CITY OF ALBUQUERQUE

June 10, 2015

**Re: Applebee's 98th St.
Erosion Sediment Control Plan
Engineer's Stamp Date 6-5-15 (K09E038)**

drawing title
Grading Plan

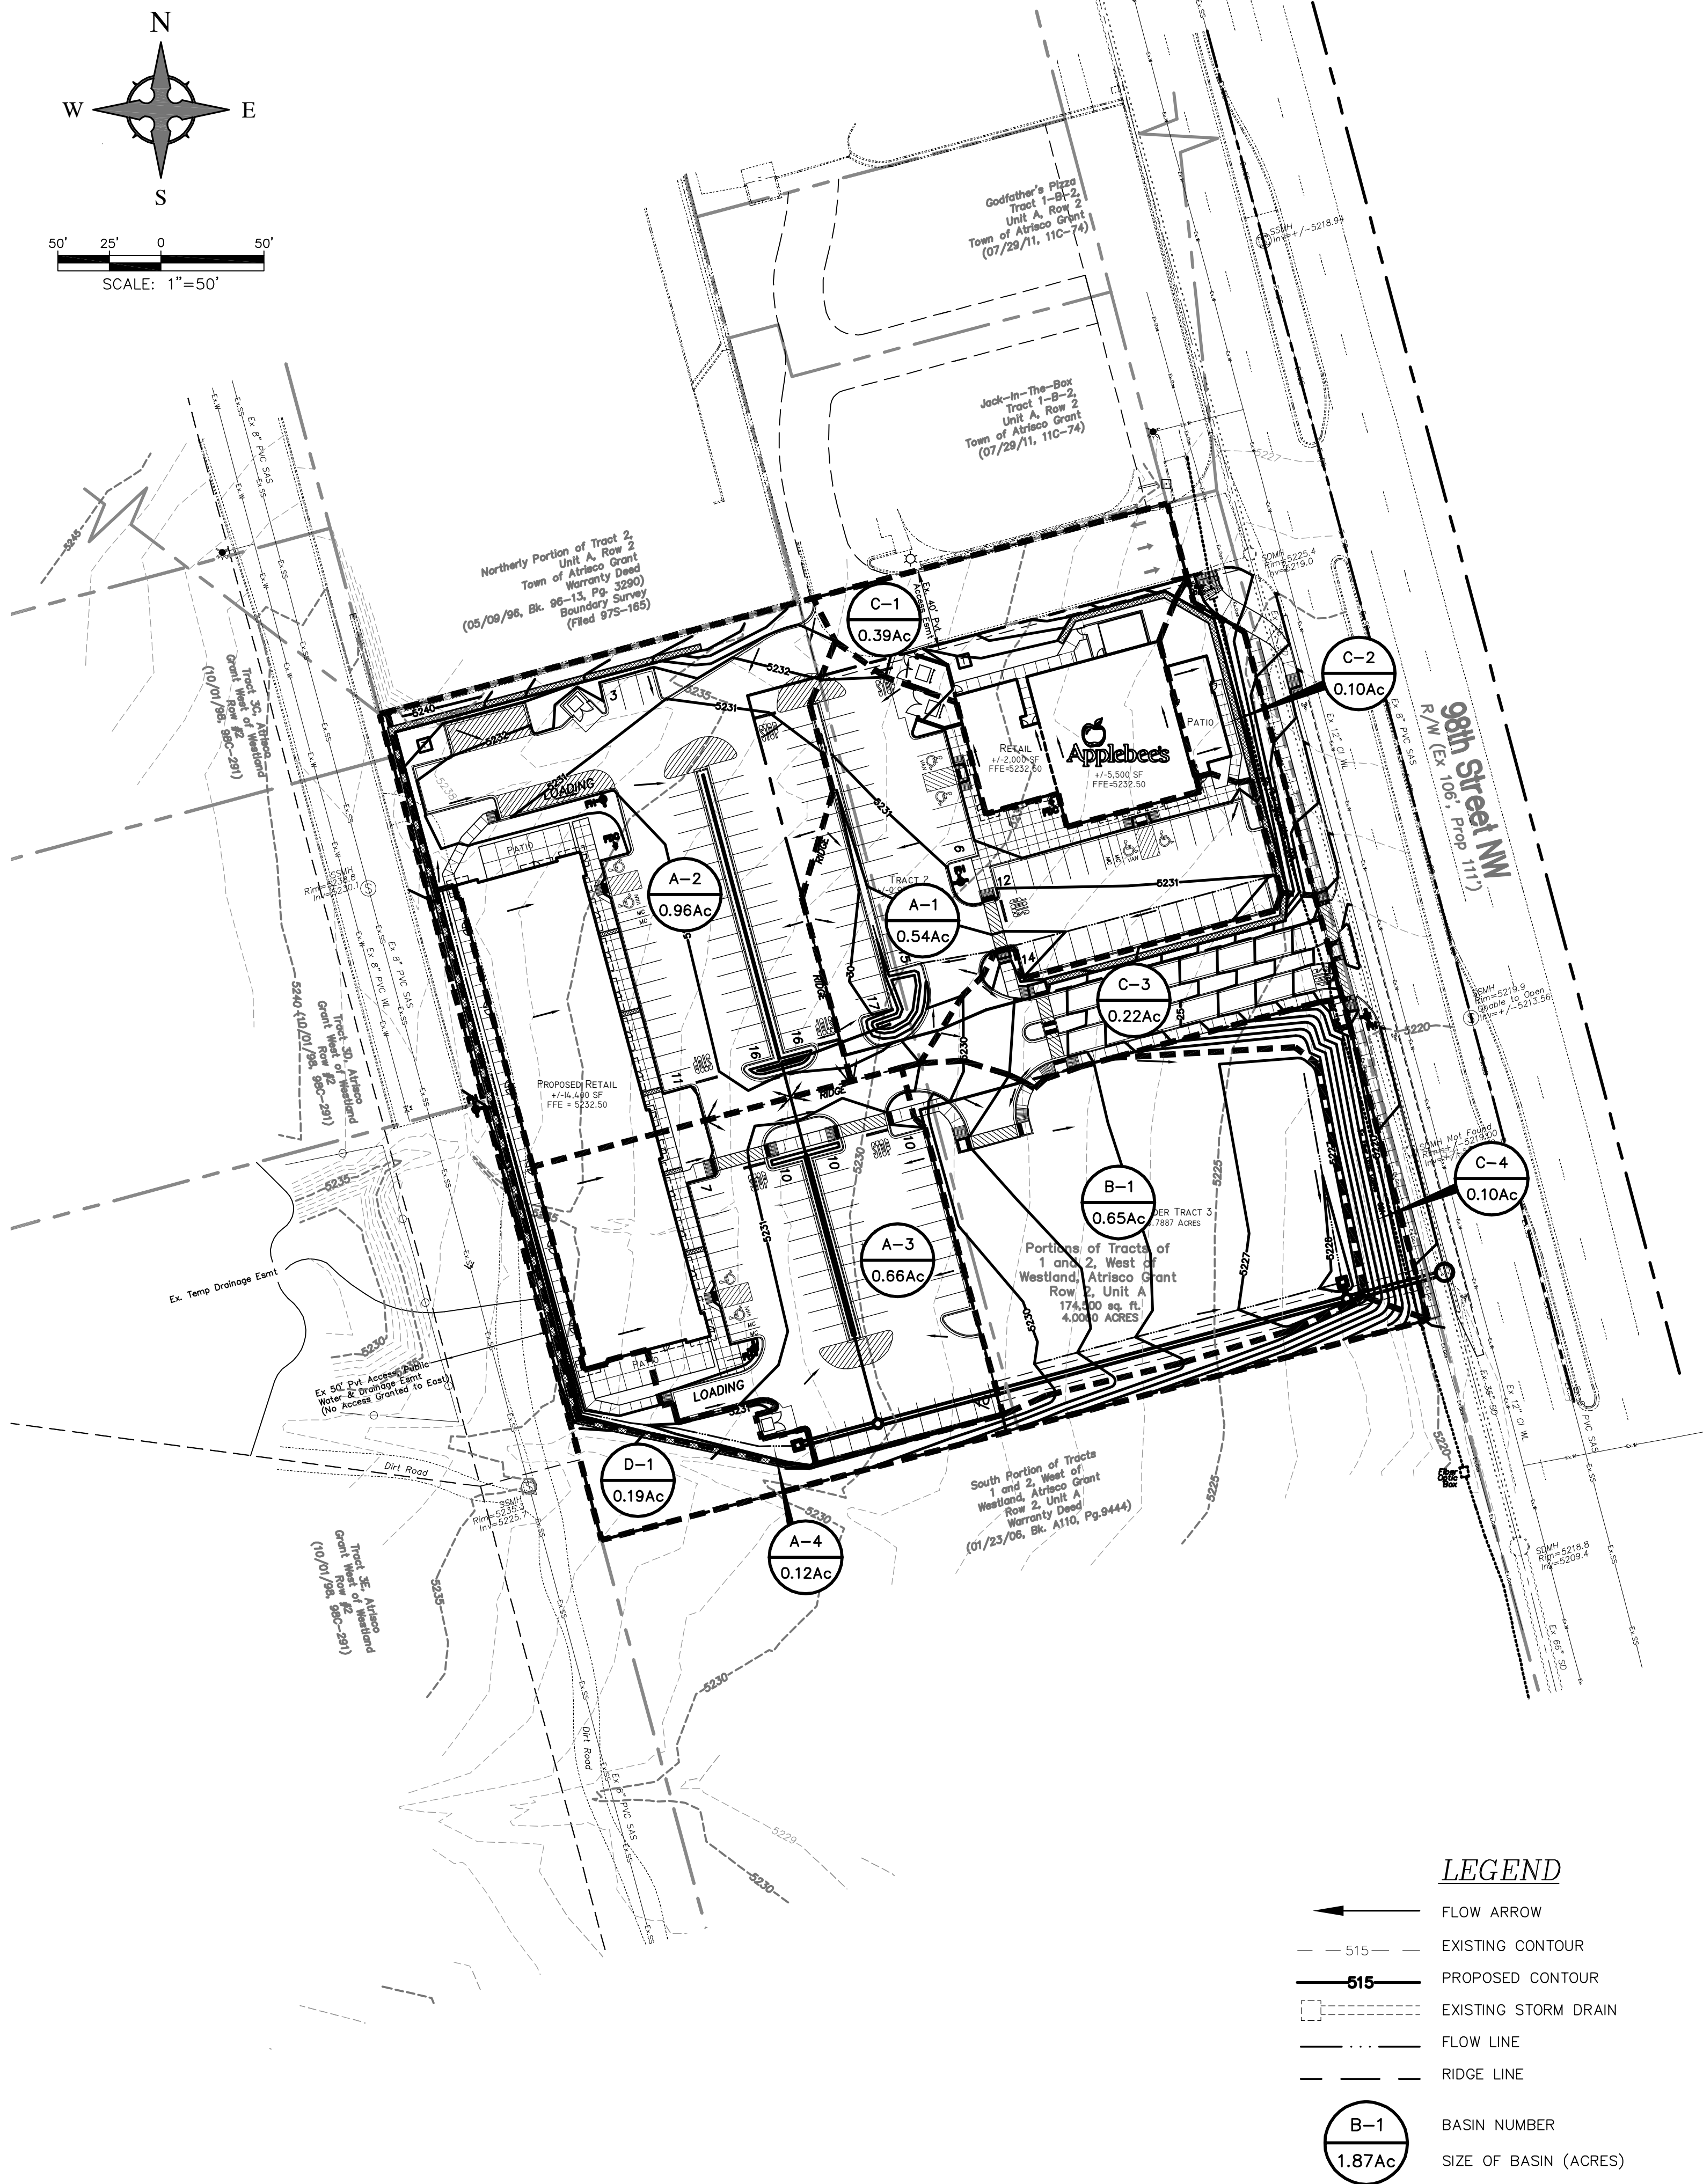
1. The BMPs shown on the plan appear adequate for the initial earth moving phase of the project. After Phase 1 is complete (Applebee's and rear building) the BMPs will have to be adjusted for the remaining out-lot.
2. When Phase 1 is complete and the out-lot is graded, it would be beneficial to construct a berm or similar to prevent the lot from draining down the steep slope on the east.
